DOC20/917295
Senders ref: SSD 10437

Russell Hand
Principal Planning Officer
Key Sites Assessments
Planning and Assessment Group
NSW Department of Planning, Industry and Environment
4 Parramatta Square
12 Darcy Street
PARRAMATTA NSW 2150

Subject: Notice of Exhibition – Waterloo Metro Quarter Over Station Development – Southern Precinct (SSD 10437)

Waterloo - OSD
 Proposed Scenario - 1% AEP
 Water Level

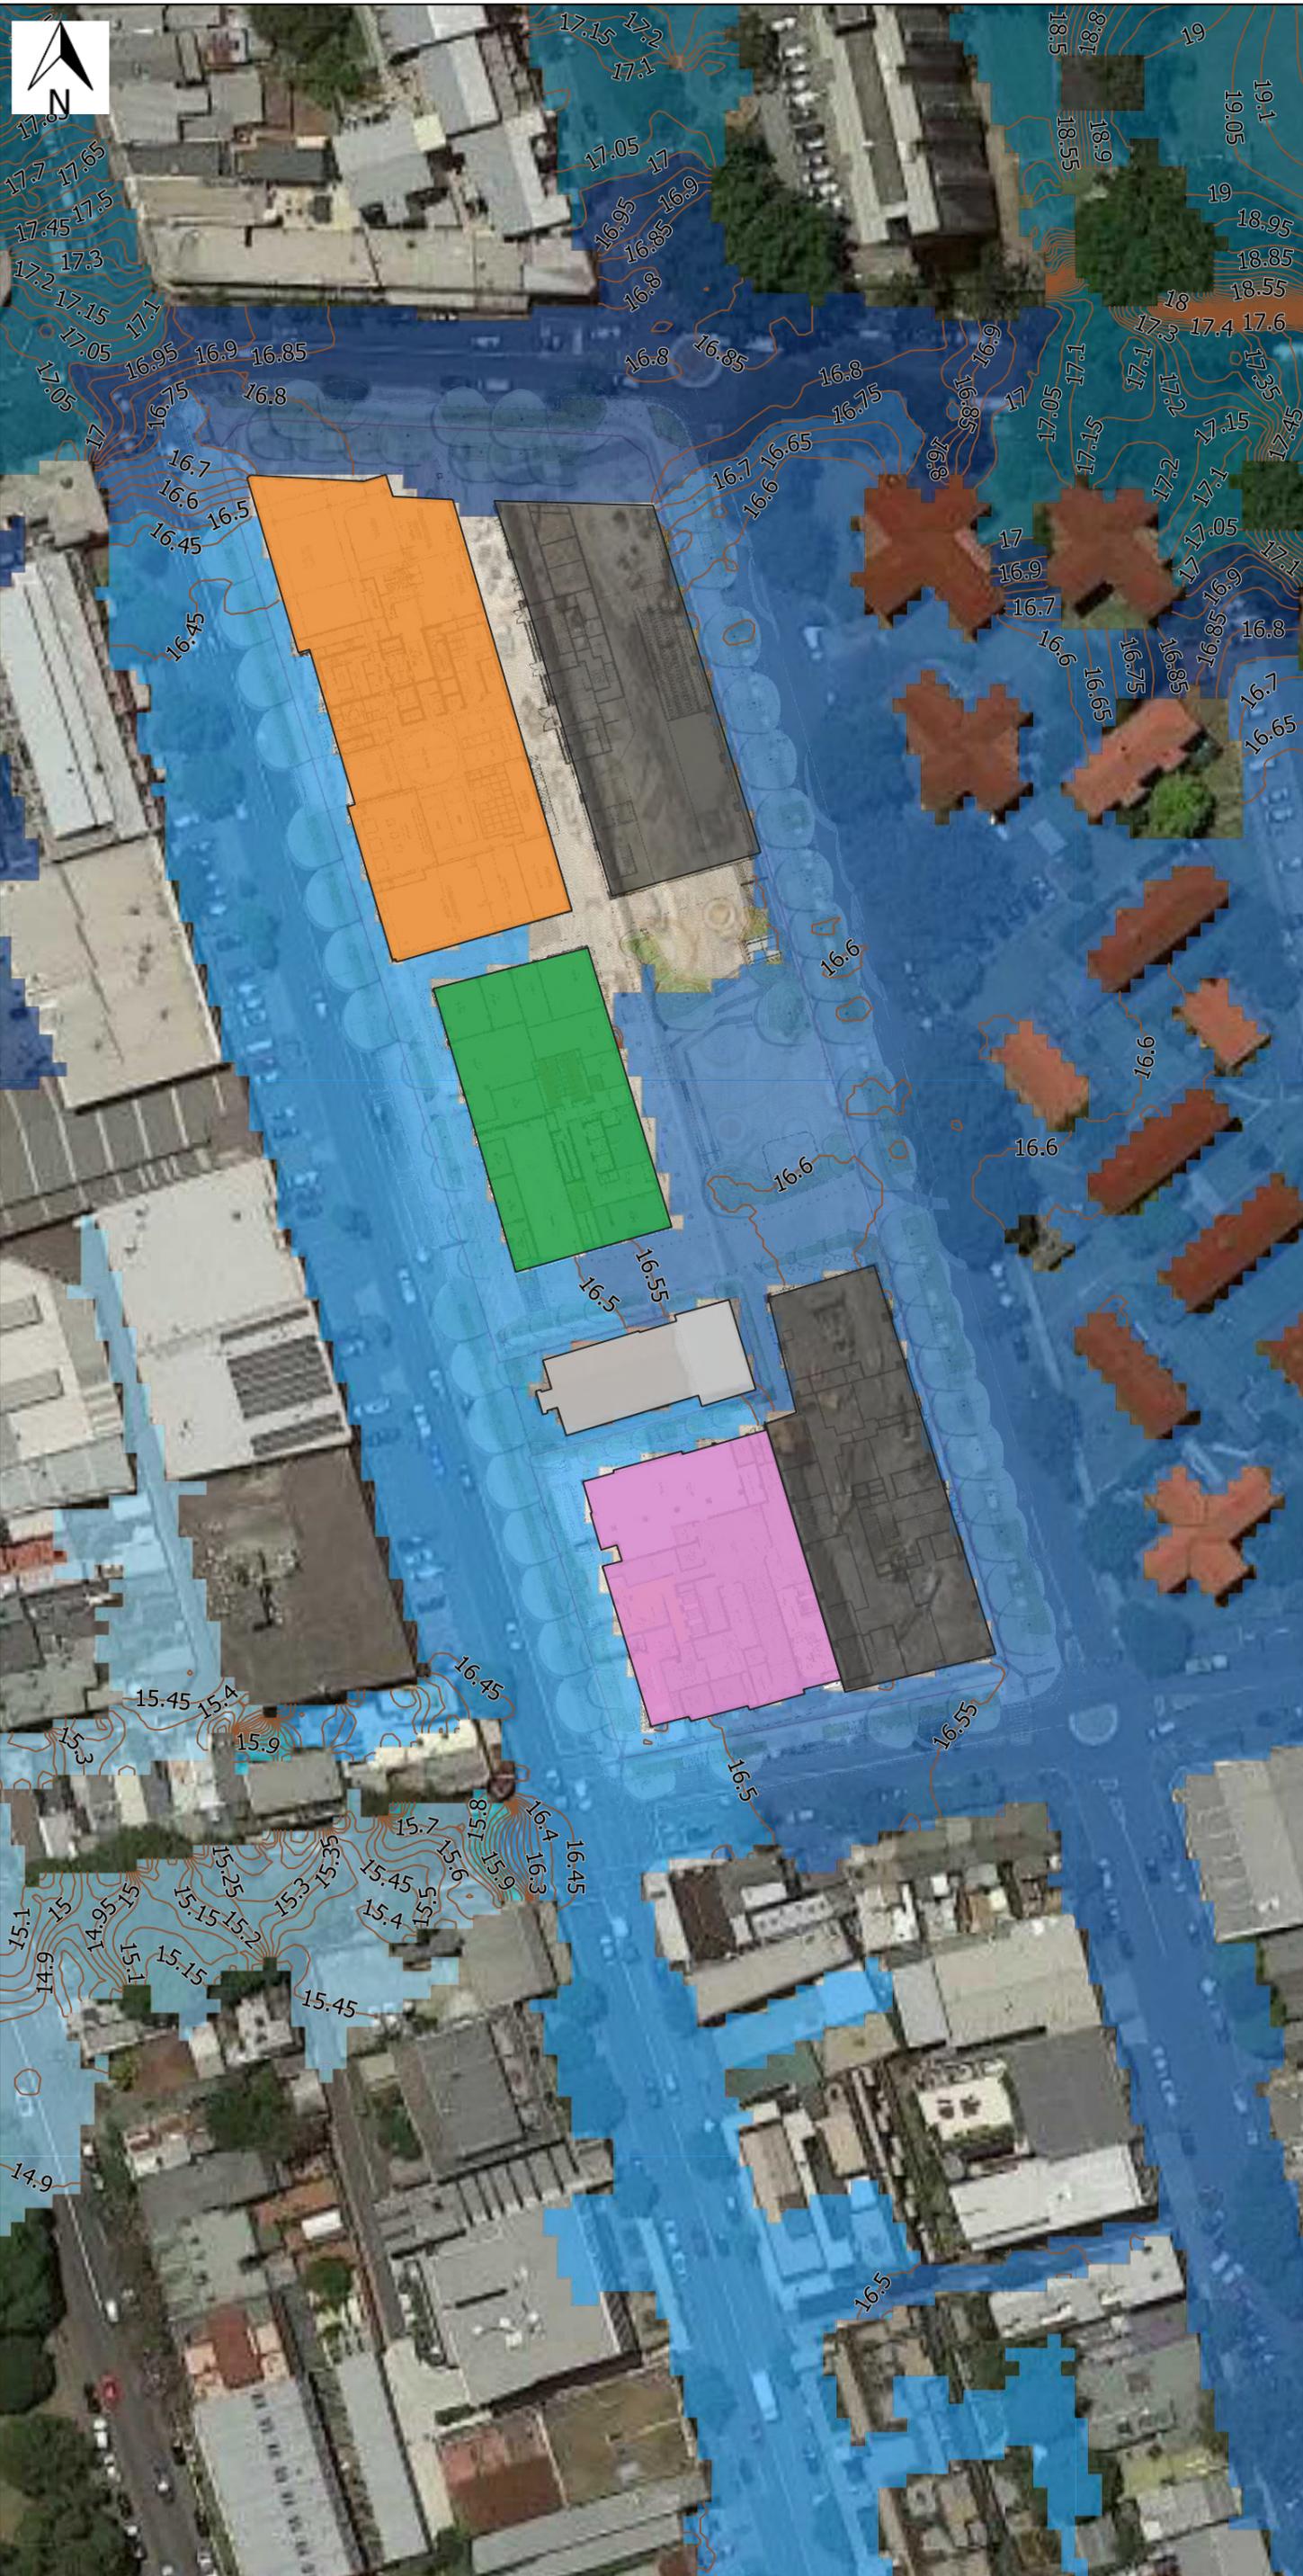
The reports have not included flood level mapping for any scenarios, except the 1% AEP flood event plus climate change. This is a significant omission. This mapping, including water level contours at appropriate intervals, must be provided as a minimum for the 5% and 1% AEP flood events and the PMF event. It is not possible to verify any of the flood level information quoted in the report without this mapping. A proper review of the submission cannot be completed until this has been provided.

The individual buildings of the over station development are not expected to cause any flood impacts; however, the ancillary road works are predicted to cause unacceptable impacts.

The current report documents flood level increases that are well in excess of the 10mm tolerance. Increases of up to 100mm are documented for both the 1% and 5% AEP flood events. It appears that an attempt has been made to justify allowing the increase in levels on the premise that these occur for a short period of time, which is not appropriate.

Limited detail has been provided on the topographical changes that would cause the predicted increase. A reduced carriageway width and reconfiguration of two intersections are changes noted in the flood report. Reference is made to the “civil design report for a detailed discussion on the proposed development topography” however, no such discussion is available in that report.
